**DELEGATED DECISION FOR APPLICATION FOR CERTIFICATE OF
LAWFUL DEVELOPMENT**

Reference no.: 2024/CL/90489/E

Site: 110, White Lee Road, White Lee, Batley, WF17
8AF

Description: Certificate of lawfulness for proposed erection of
outbuilding and rear dormer with hip to gable roof

**PROPOSED OUTBUILDING FLOOR PLAN**  
Scale:1:50

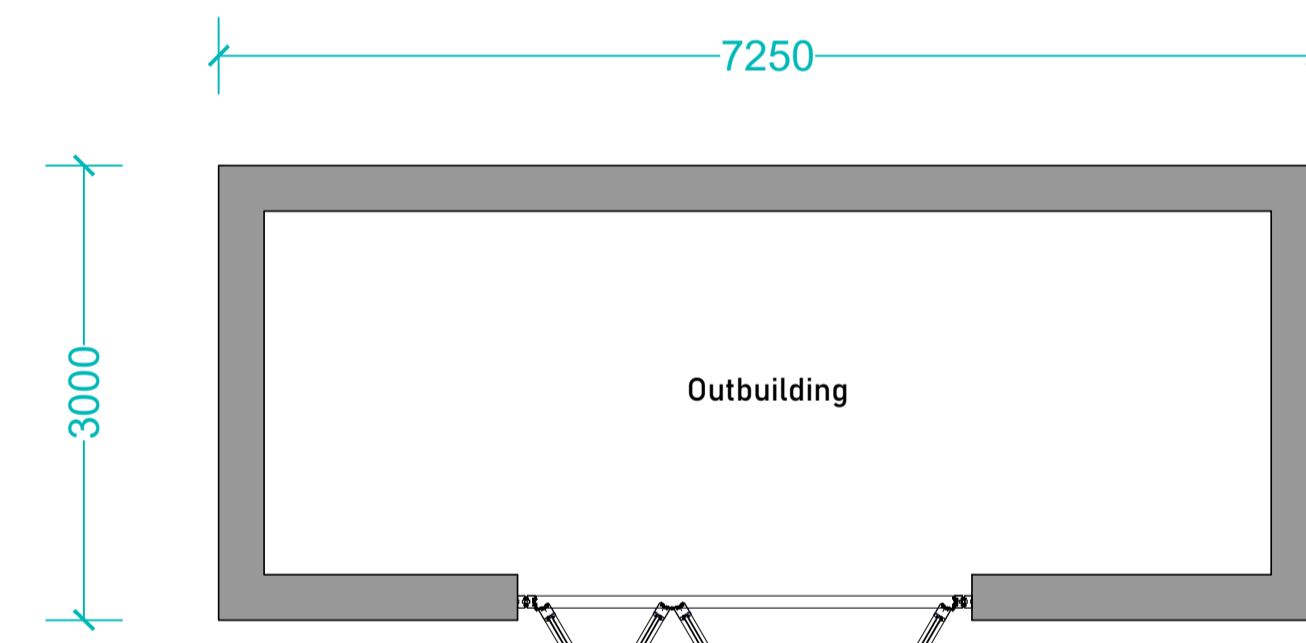
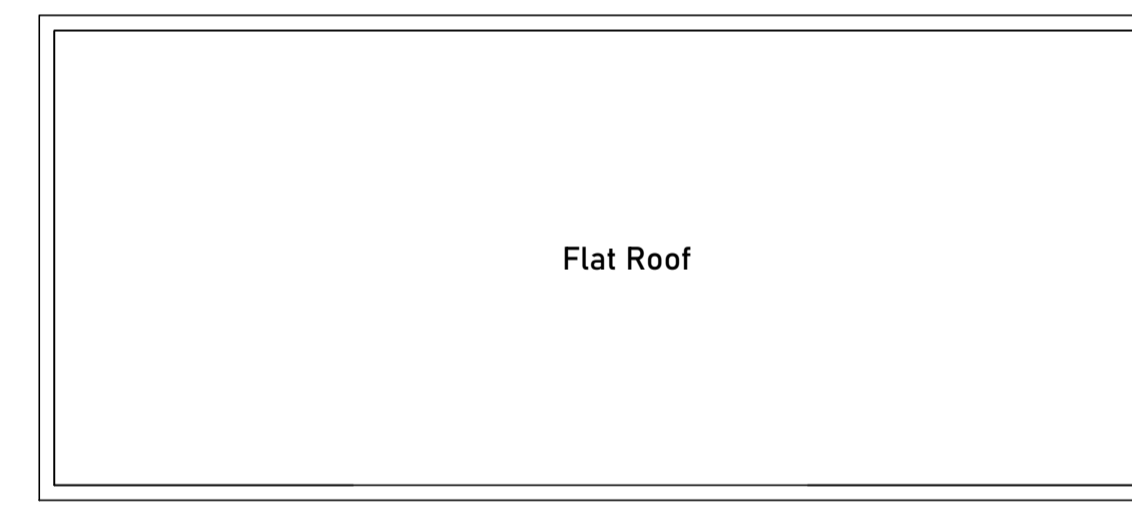
Comment: the building would be single storey in scale.

Comment: the building would not exceed 3 metres in height.

Comment: the height of the eaves of the building would not exceed 2.5 metres.

REV.	DATE	DESCRIPTION	DRAWN BY:	CHECKED BY:
CLIENT: MR TAHIR RAFIQ				
PROJECT ADDRESS: 110 WHITE LEE ROAD, BATLEY, WF17 8AF				
PROJECT NAME: PROPOSED HIP TO GABLE ROOF WITH REAR DORMER AND PROPOSED OUTBUILDING				
DRAWING TITLE: PROPOSED PLANS AND ELEVATIONS

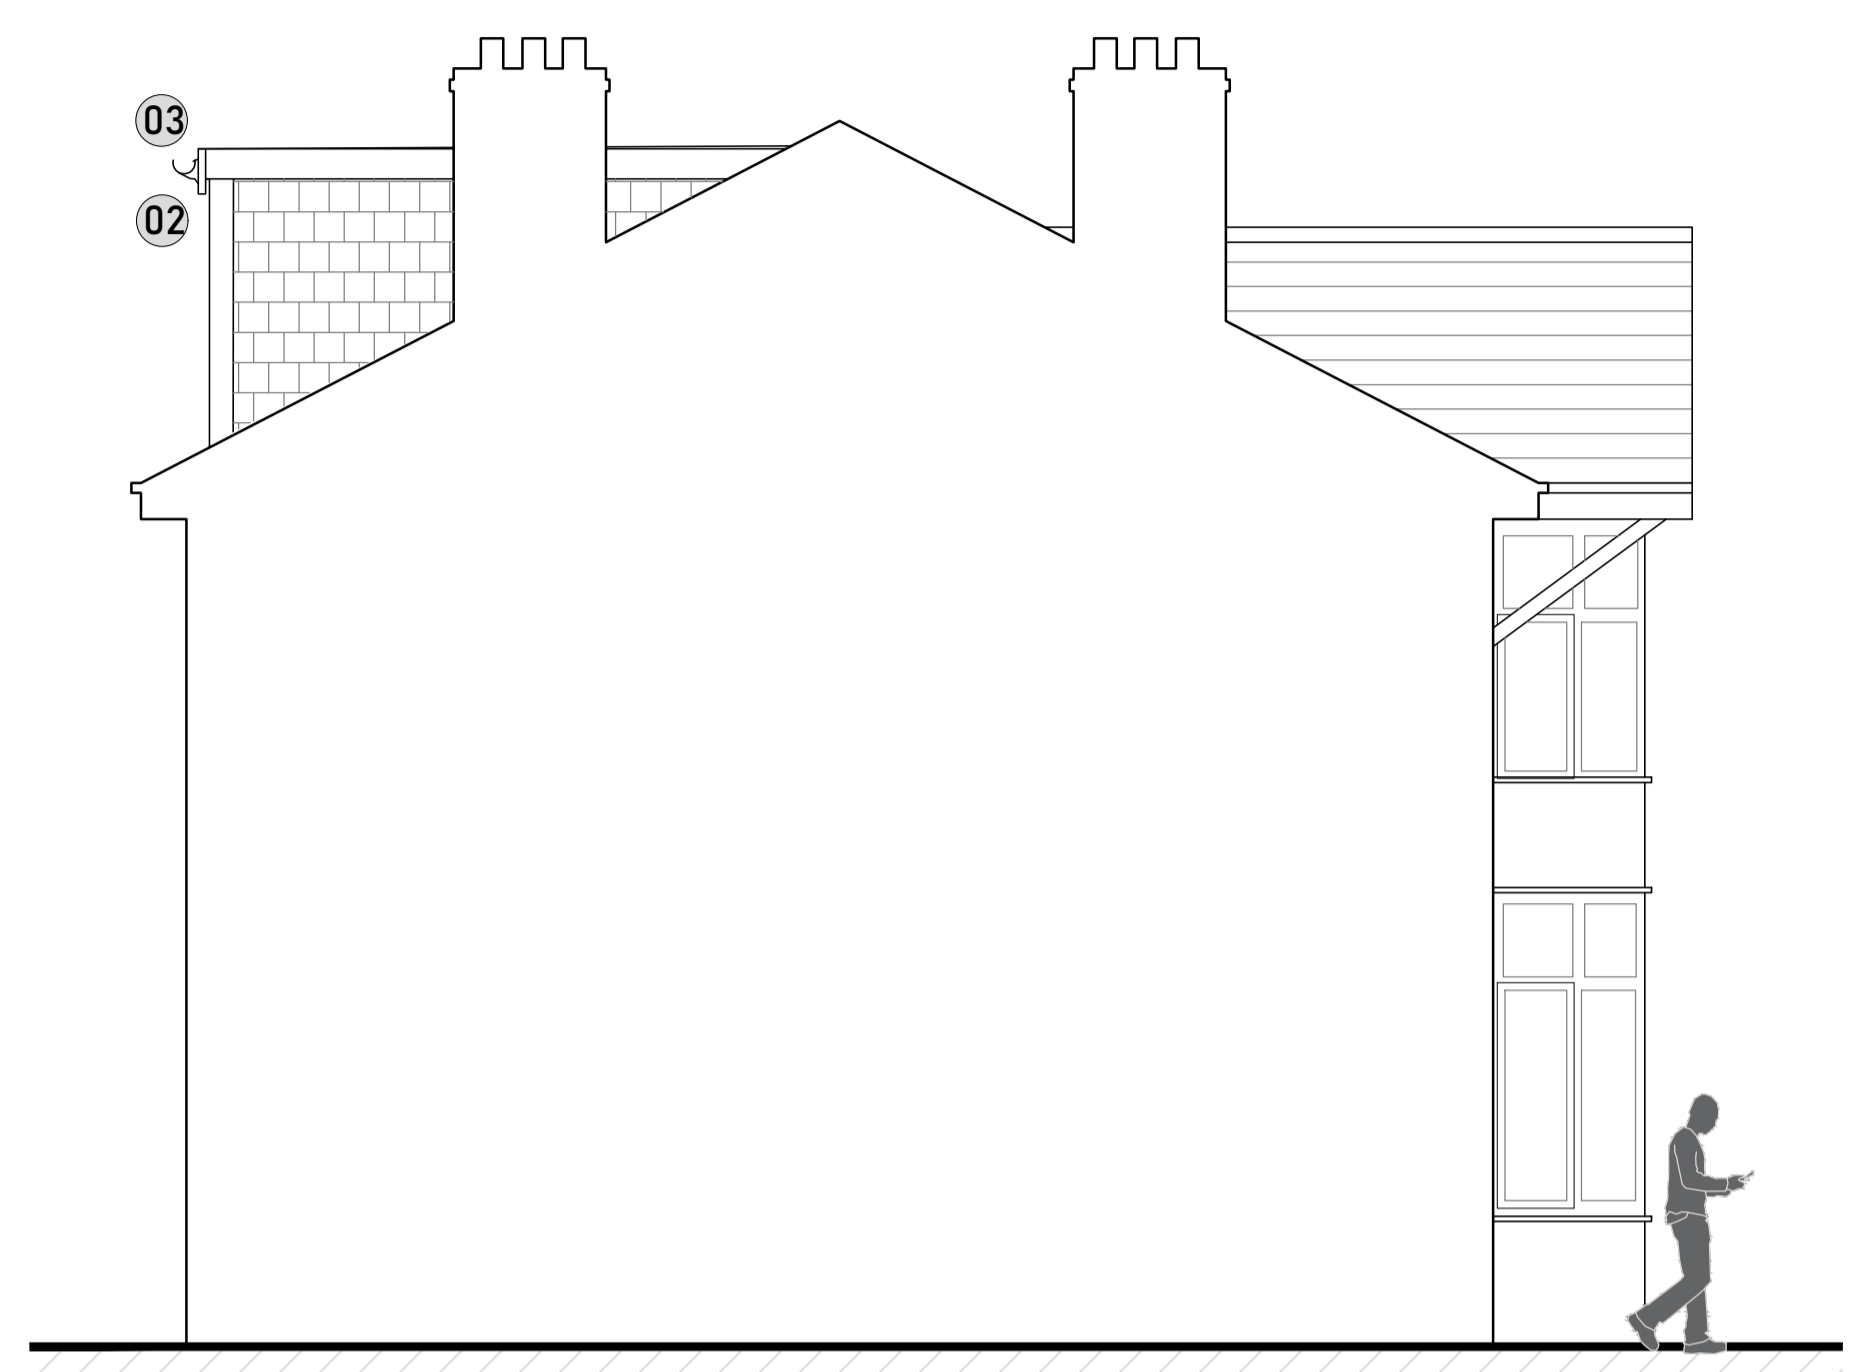
Comment **As can be seen from the elevations, no part of the dwellinghouse would exceed the height of the highest part of the existing roof.**

Comment **No part of the dwellinghouse would extend beyond the plane of the existing roof slopes visible from the principal elevation.**
